Application by SEGRO Properties Limited for an order granting consent for the East Midlands Gateway Phase 2 (BC0410001) and East Midlands Rail Freight Interchange Material Change (TR0510002)

Deadline 5 submission

Leicestershire County Council Deadline 5 submission – 30.06.2026

Drawing Title  
**HIGHWAY PLANS GENERAL ARRANGEMENT SHEET 1 OF 4**

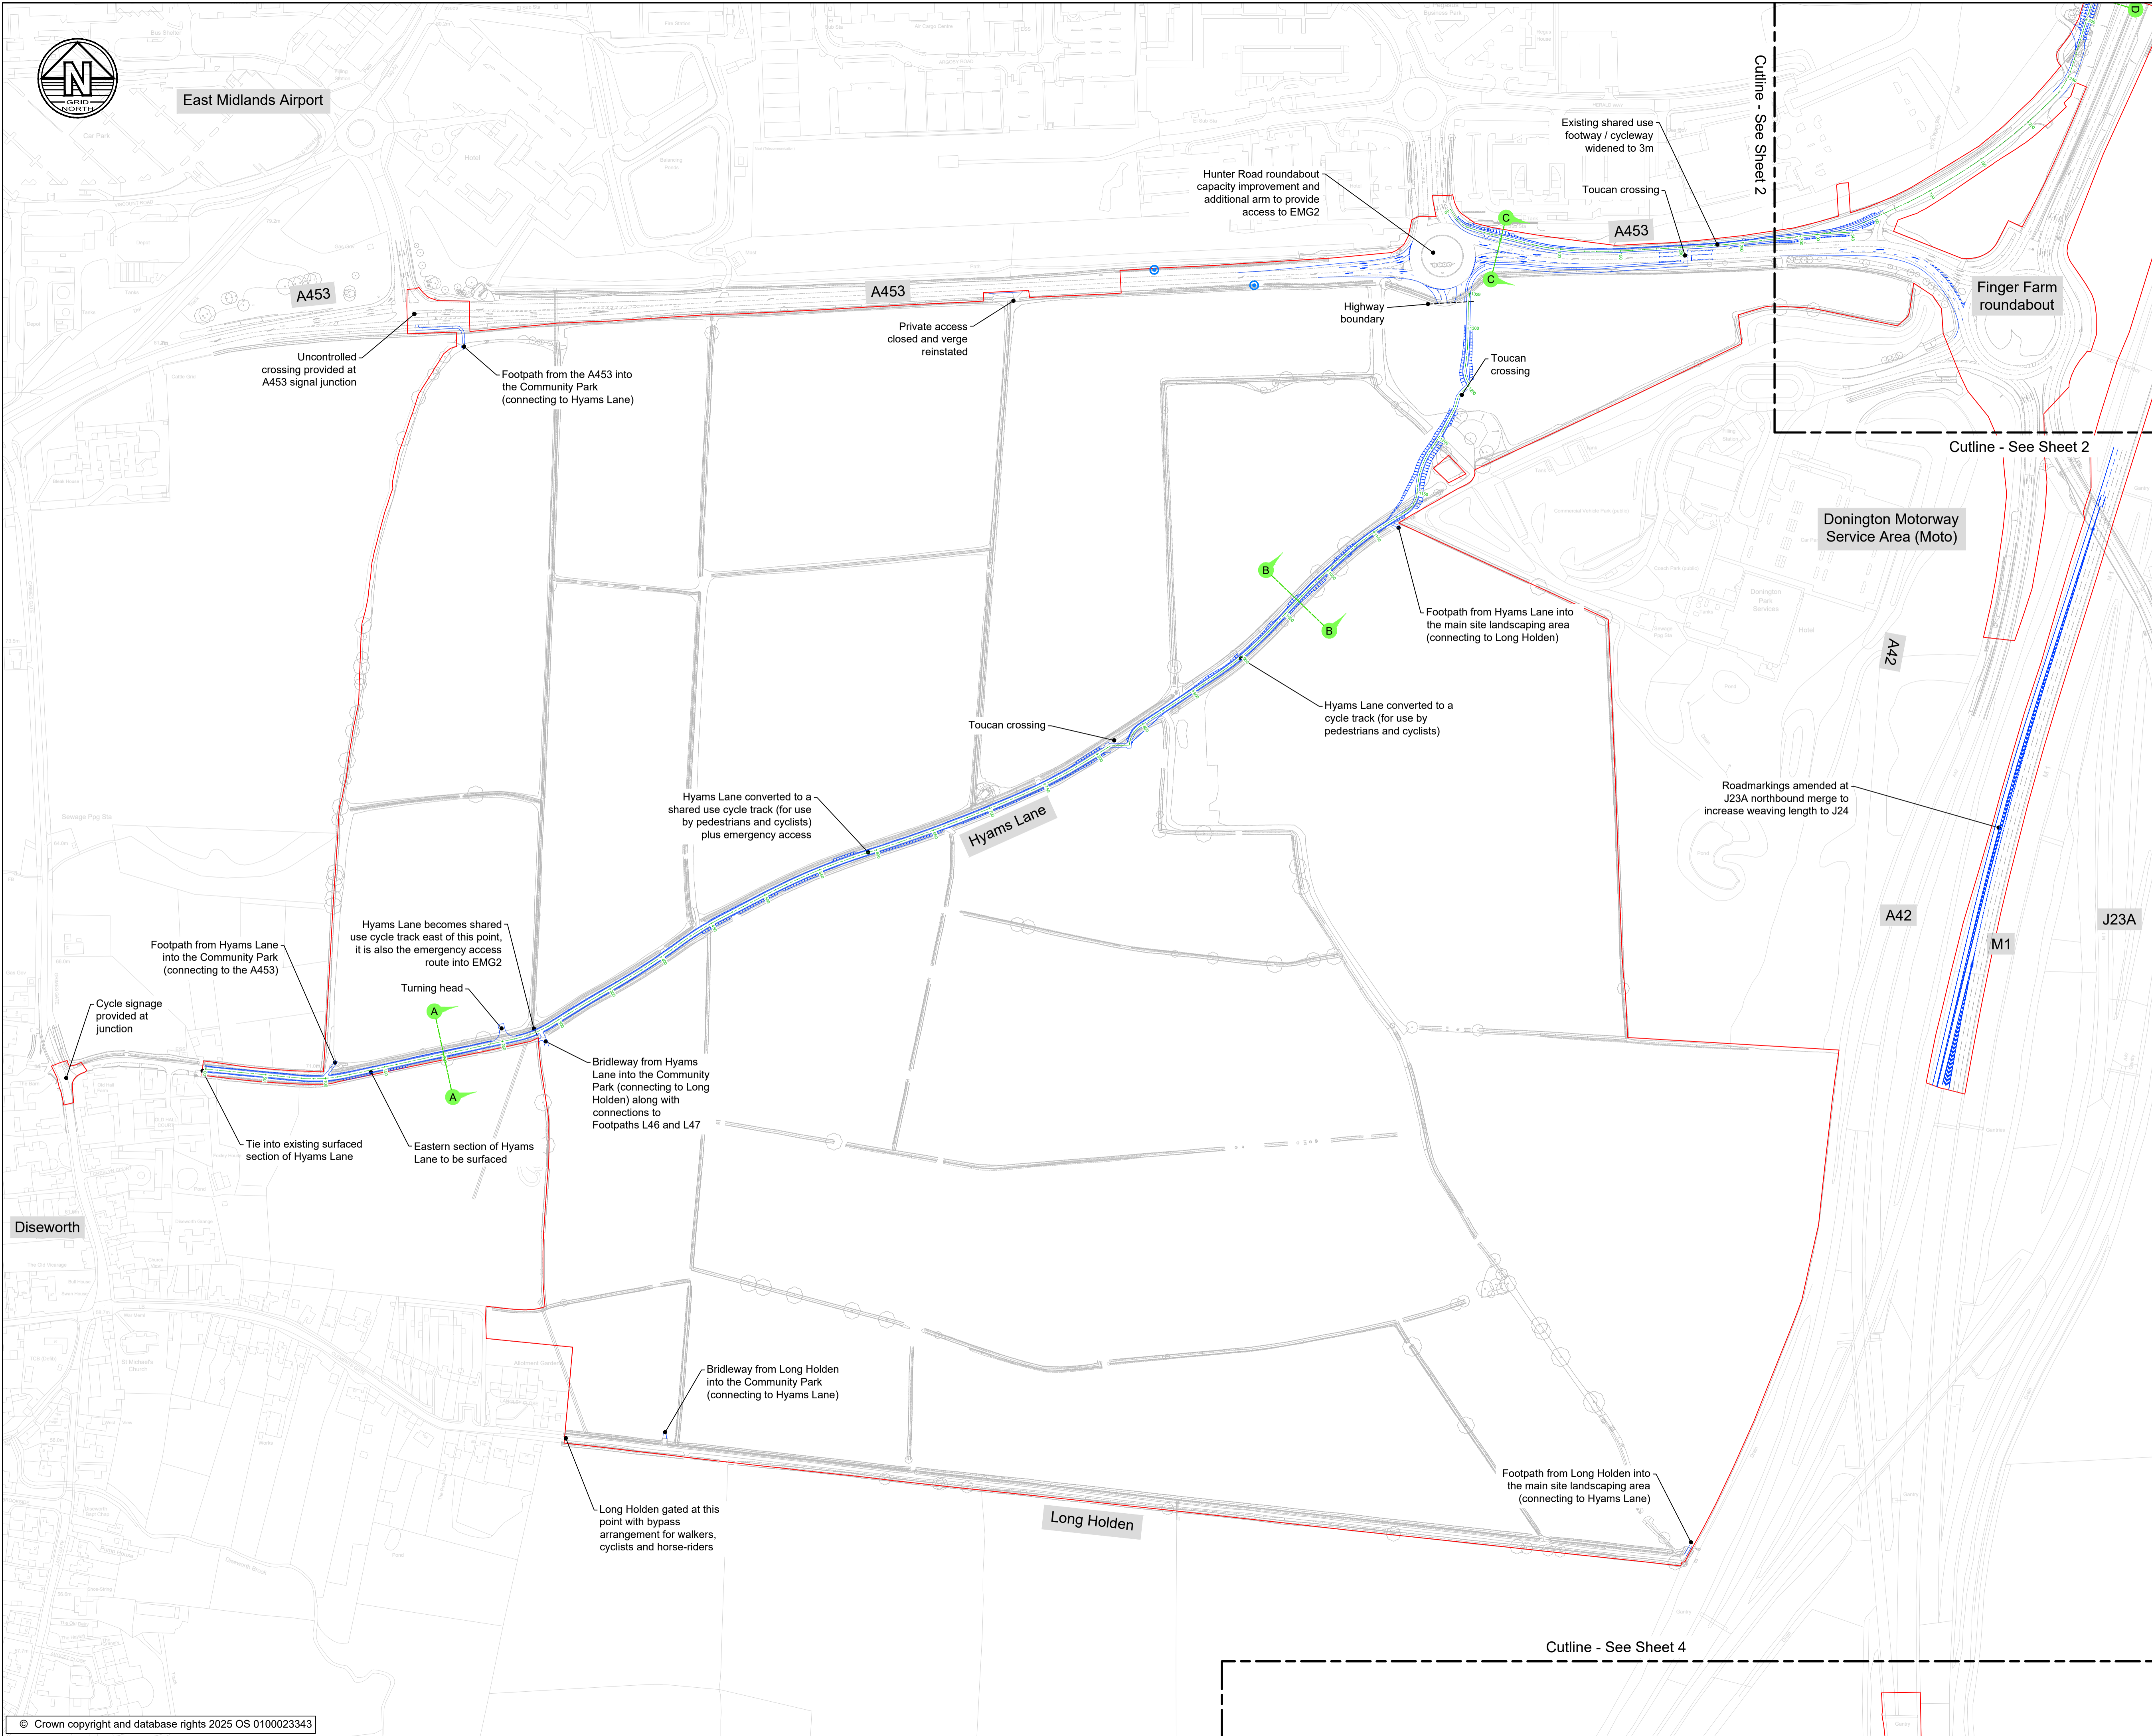
REP4-011D	Highway Plans General Arrangement Sheet 1	Amendment to reflect the introduction of a controlled pedestrian crossing on A453 – LCC welcome this amendment.
REP4-012D	Highway Plans General Arrangement Sheet 2	Amendment to reflect the revised alignment of the ATL - LCC have no comments to make on this amendment.
REP4-013D	Highway Plans Cross Sections Sheet 2	Amendment to reflect the revised alignment of the ATL - LCC have no comments to make on this amendment.
REP4-014D	Highway Plans Long Sections Sheet 3	Amendment to reflect the revised alignment of the ATL - LCC have no comments to make on this amendment.
REP4-015D	Community Park Plan	Additional footpath added - see response to ExQ2 1.2.1 for further details – LCC have no comments to make on this amendment.
REP4-019	Appendix 3A of the ES - CEMP	Updated Construction Traffic Management Plan to address comments made by Leicestershire County Council at ISH3– LCC note an error in this revised document. Incorrect reference is made to the Pan Regional Transport Model being a Paramics model. This is not the case. LCC remains concerned with the associated proposed disapplication of section 141 of the Highways Act 1980 as set out in Schedule 14 of the dDCO and as documented in LCC’s submissions at deadline 1 [REP1-087] and deadline 4 [REP4-060D].
